Address: 44 Station Road Huddersfield HD8 0AD

Application number: 2025/91627	
What is the application for?:	Erection of two storey extension to side and front, balcony to rear and associat
Address of the site or building:	42A, Station Road, Fenay Bridge, Huddersfield, HD8 0AD
Postcode:	HD8 0AD

Proposed Elevations

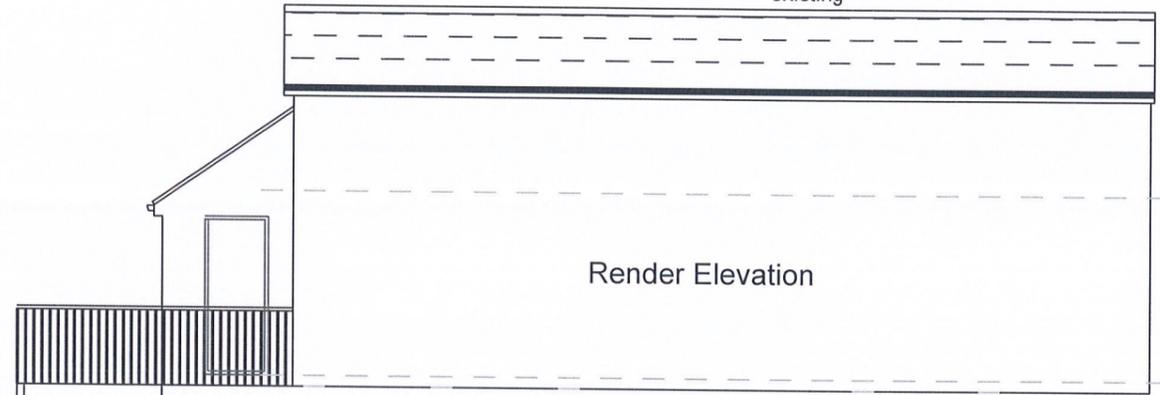
The rule of 45 degrees results in visual sight of the extension from more than one habitable room in my property, thus affecting the outlook from it.

This application to extend the existing dwelling, will certainly result in an overbearing structure that is disrespectful of the area. It will afford the proposed property, upon completion, a privileged outlook, which is to the detriment of others.
